CITY OF ALBUQUERQUE

April 12, 2018

Re: Holiday Bowl, 7515 Lomas Blvd. NE
Traffic Circulation Layout
Engineer's Stamp **03-26-18** (J19-D082A)

EAST DRIVEPAD ADA PLAN  
H C.4  
NTS

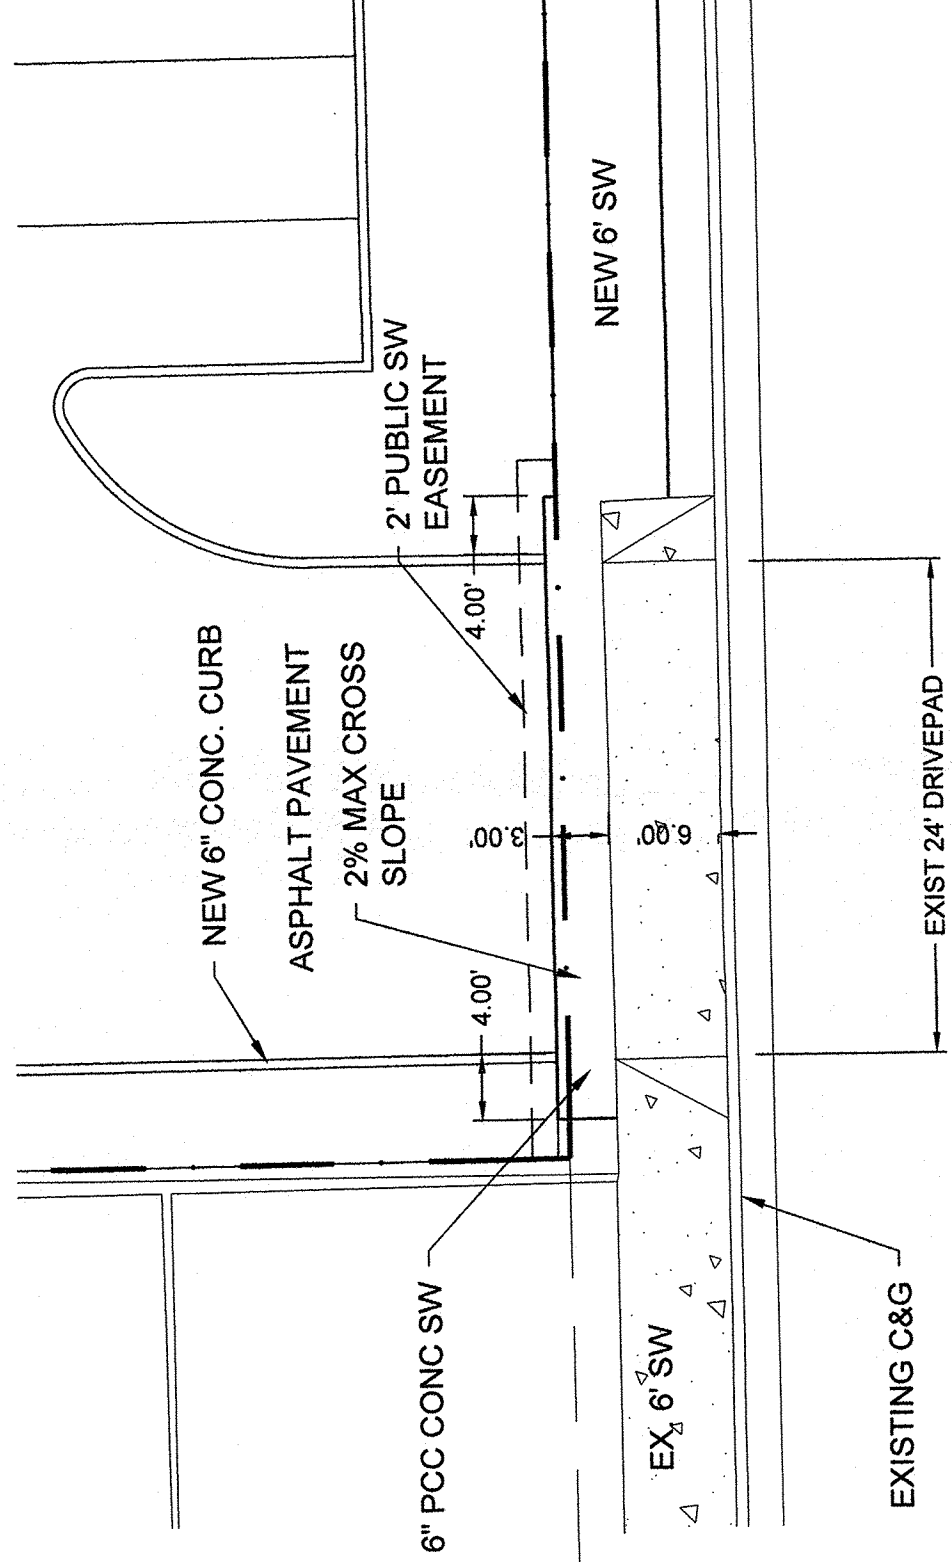
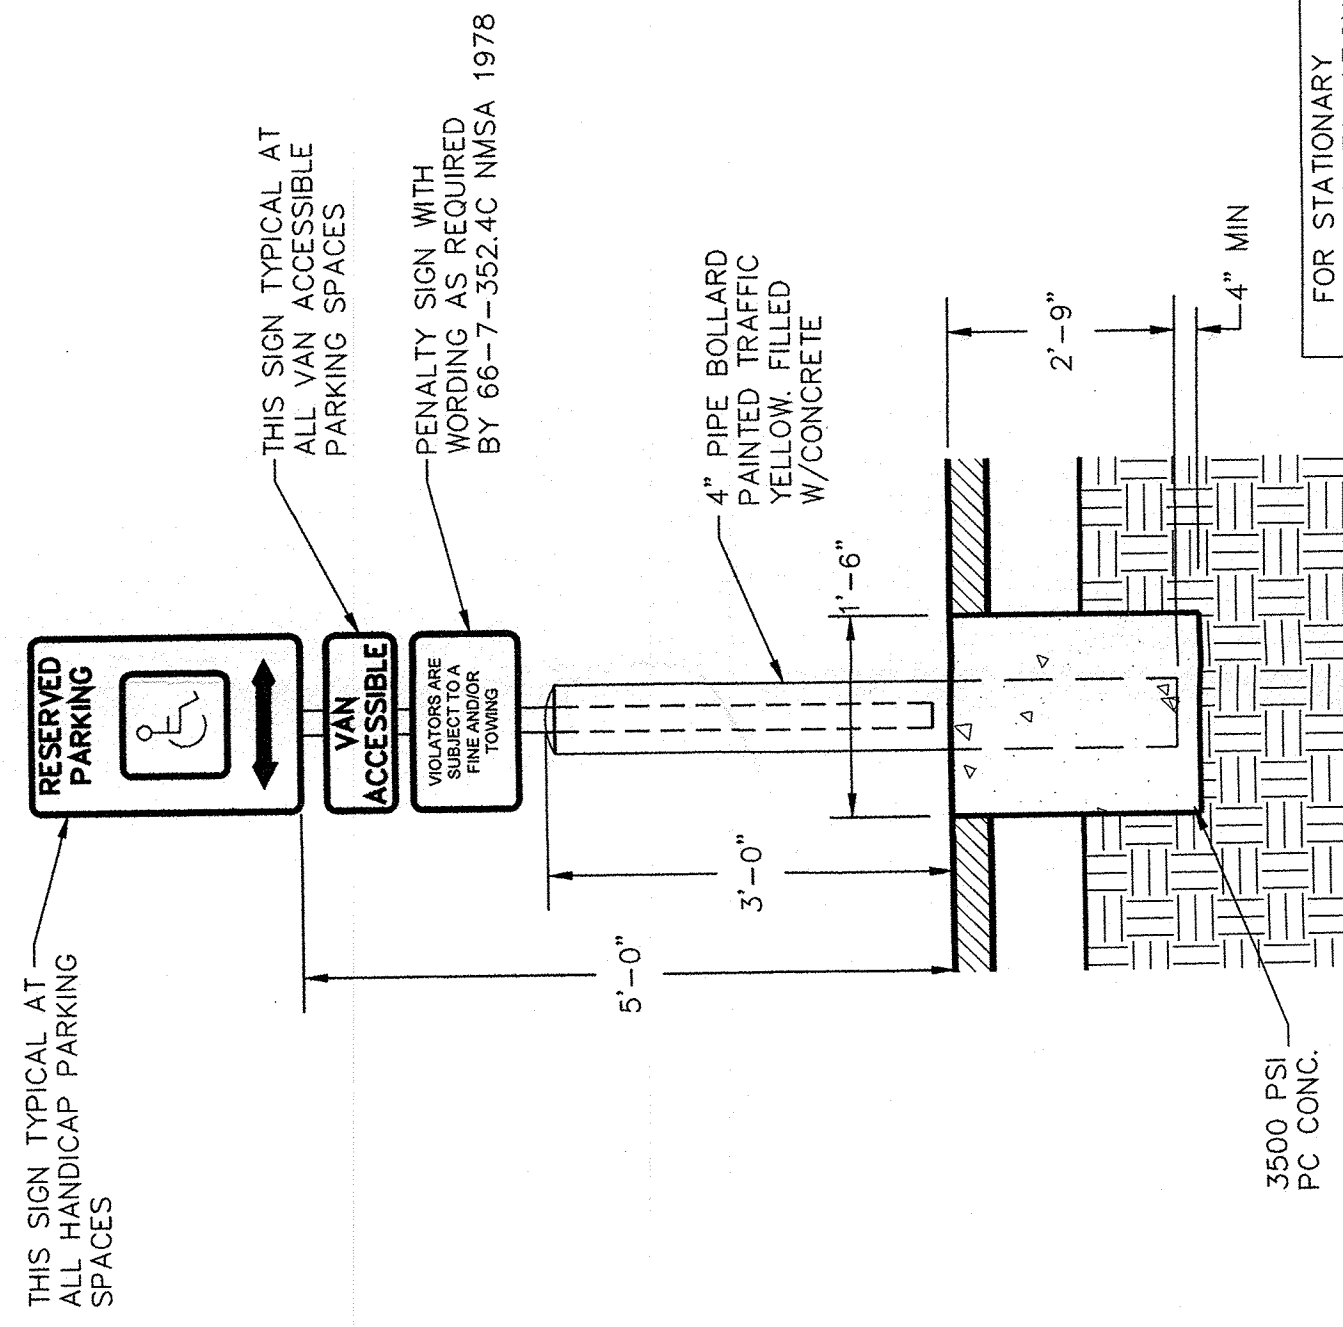
1. The handicap accessible spaces must include an access aisle. Van accessible aisles should be 8ft wide; all others should be 5ft wide.
2. The ADA accessible parking sign must have the required language per 66-7-352.4C NMSA 1978 **"Violators Are Subject to a Fine and/or Towing."** Please call out detail and location of HC signs.

3. The ADA access aisles shall have the words **"NO PARKING"** in capital letters, each of which shall be at least one foot high and at least two inches wide, placed at the rear of the parking space so as to be close to where an adjacent vehicle's rear tire would be placed. (66-1-4.1.B NMSA 1978)

DO NOT ENTER - ONE WAY SIGN DETAIL
NTS

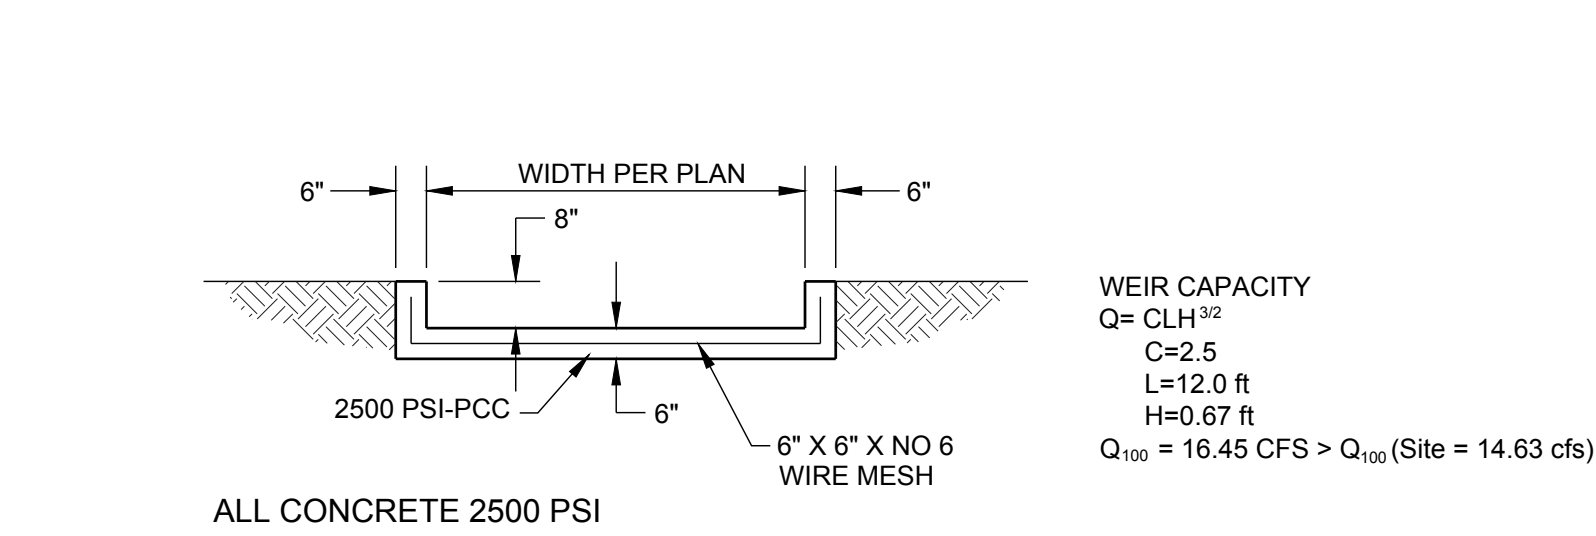
8. Service vehicle and/or refuse vehicle maneuvering must be contained on-site; provide a copy of refuse approval.
9. One-way vehicular paths require pavement directional signage and a posted **"Do Not Enter"** sign at the point of egress. Please show detail and location of posted signs. Drive aisles are 24 feet for two way travel.
